Our Ref: RVBC-MH-APP-002 (2)

Date: 26/January/2022

**PLANNING APPLICATION Ref: 3/2021/0661 - Haweswater Aqueduct Resilience Programme  
Proposed Marl Hill Section (Ribble Valley Borough Council)**

**APPLICATION UPDATES**

FIGURE 6.5

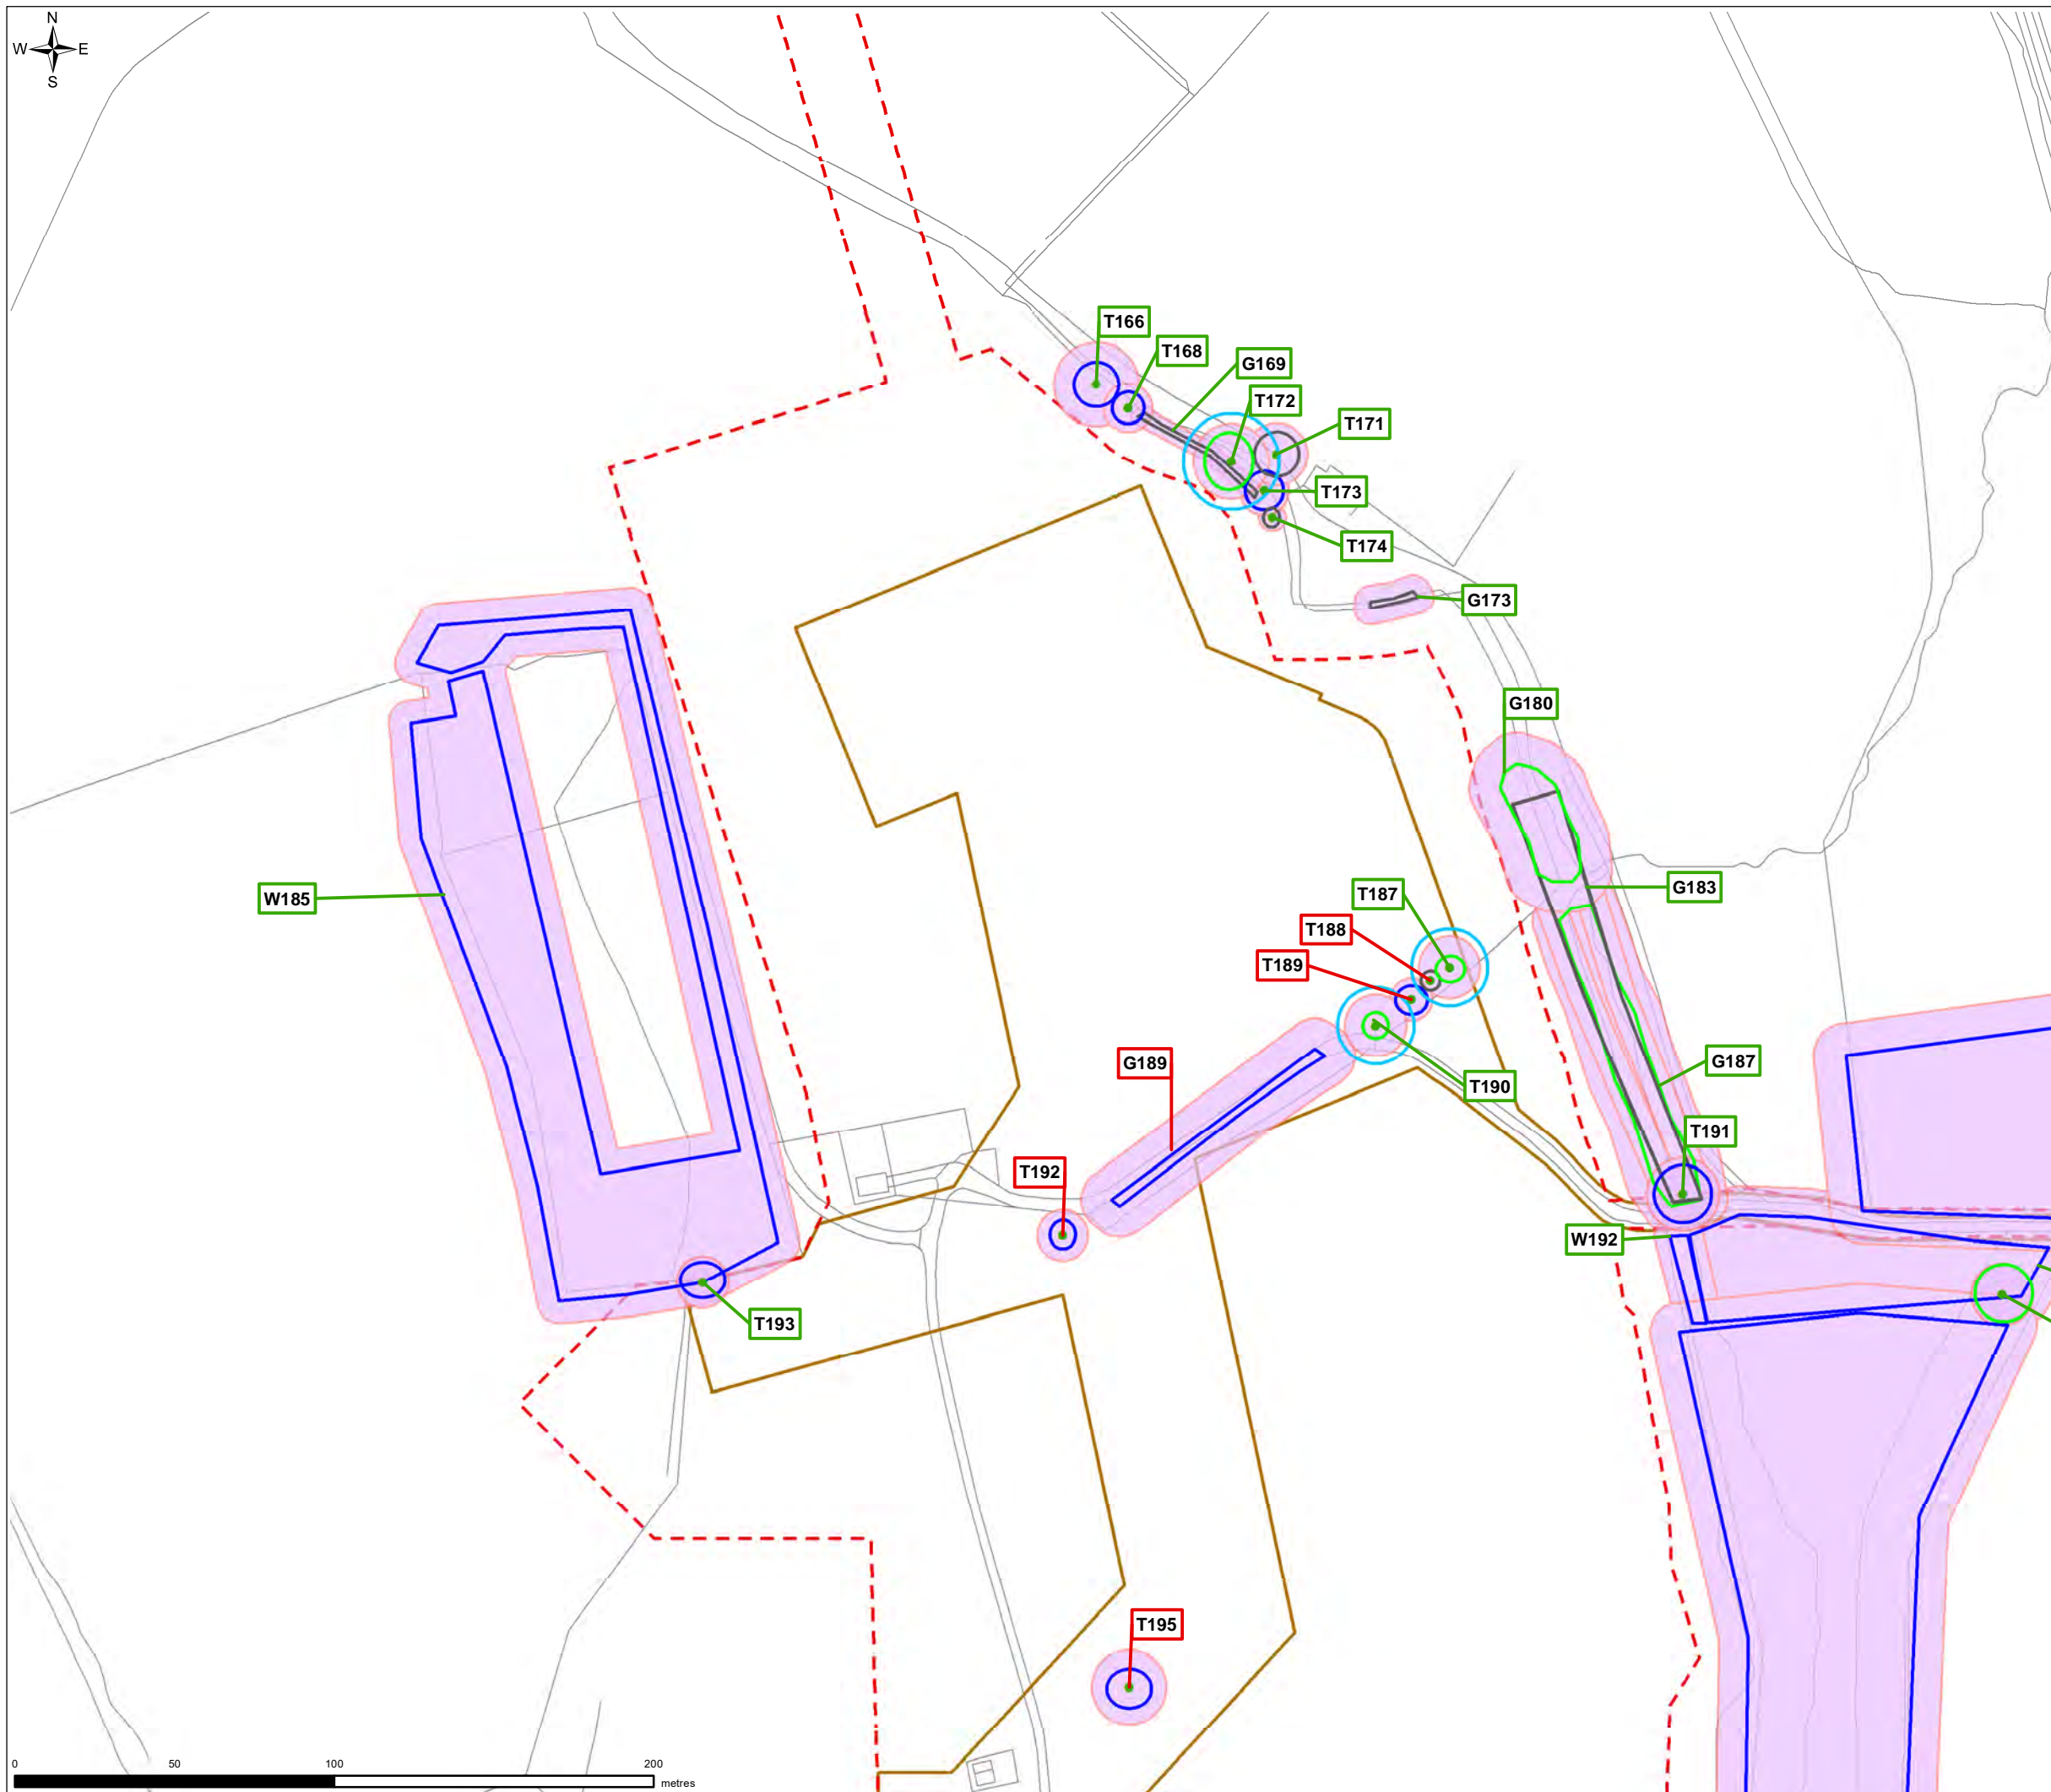
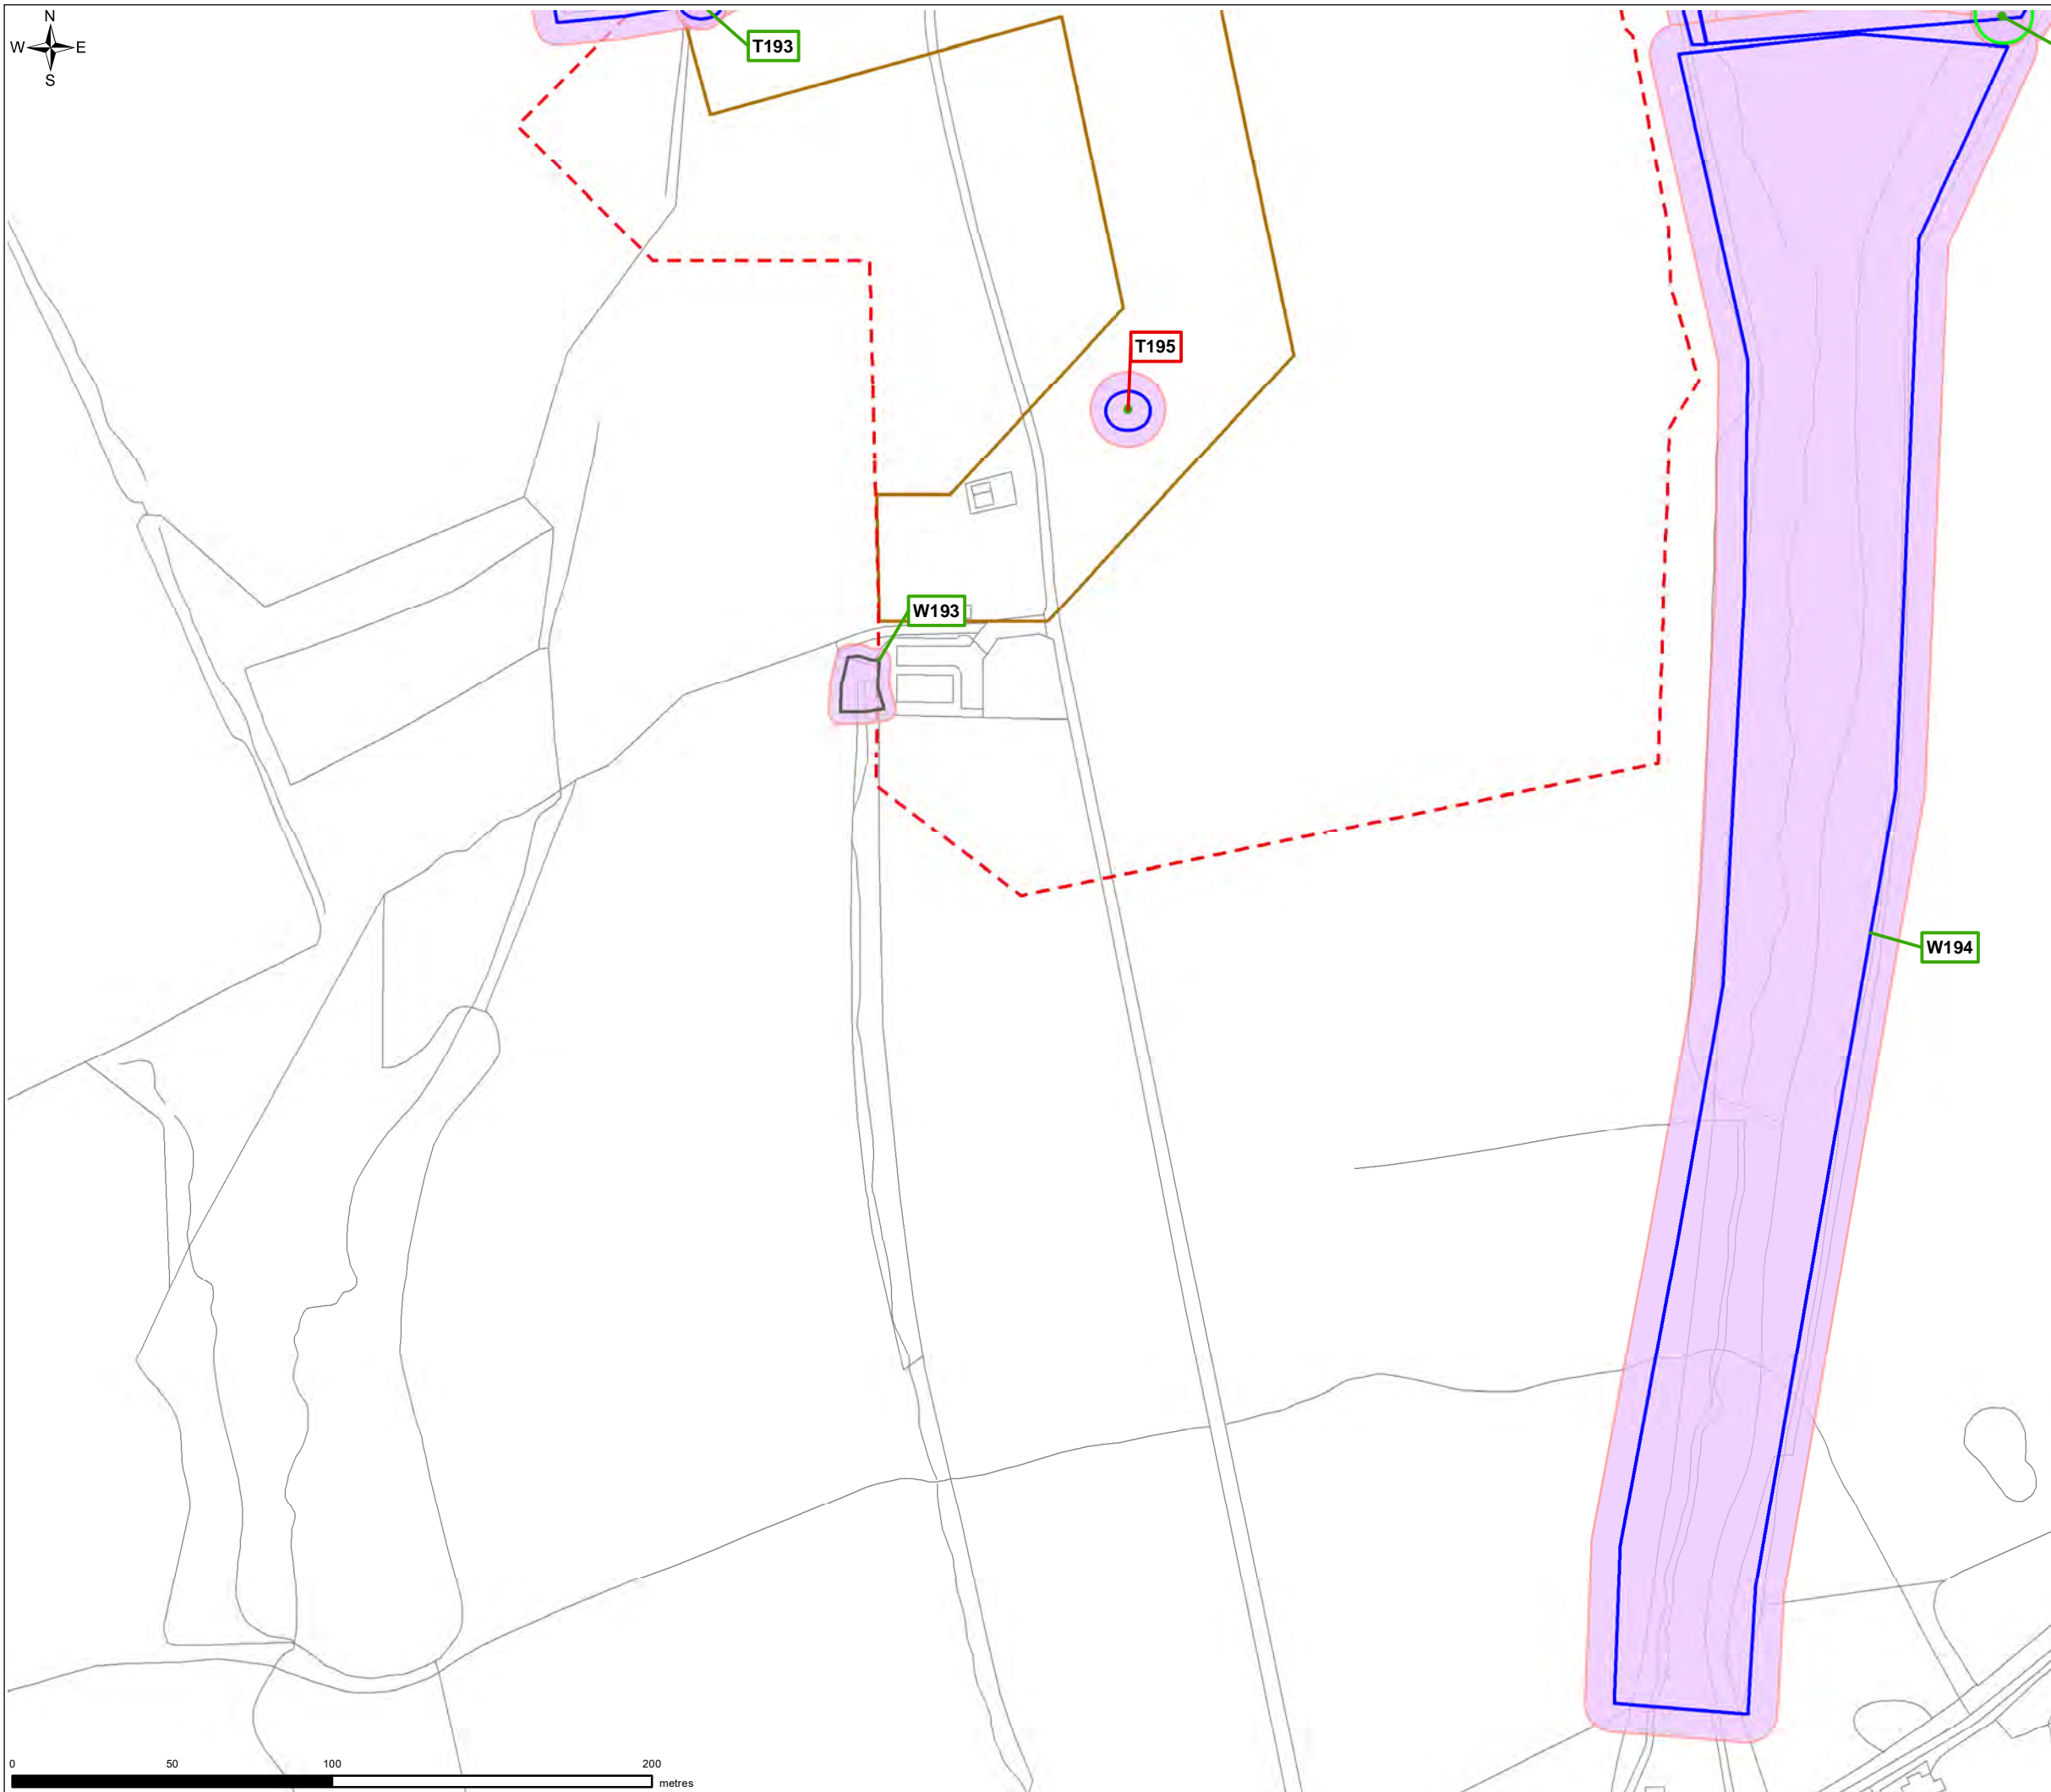
Further design refinement has led to the avoidance of some previously proposed affected trees within the construction compounds and these are reflected on the updated Series 3 - Site Layout Plans.
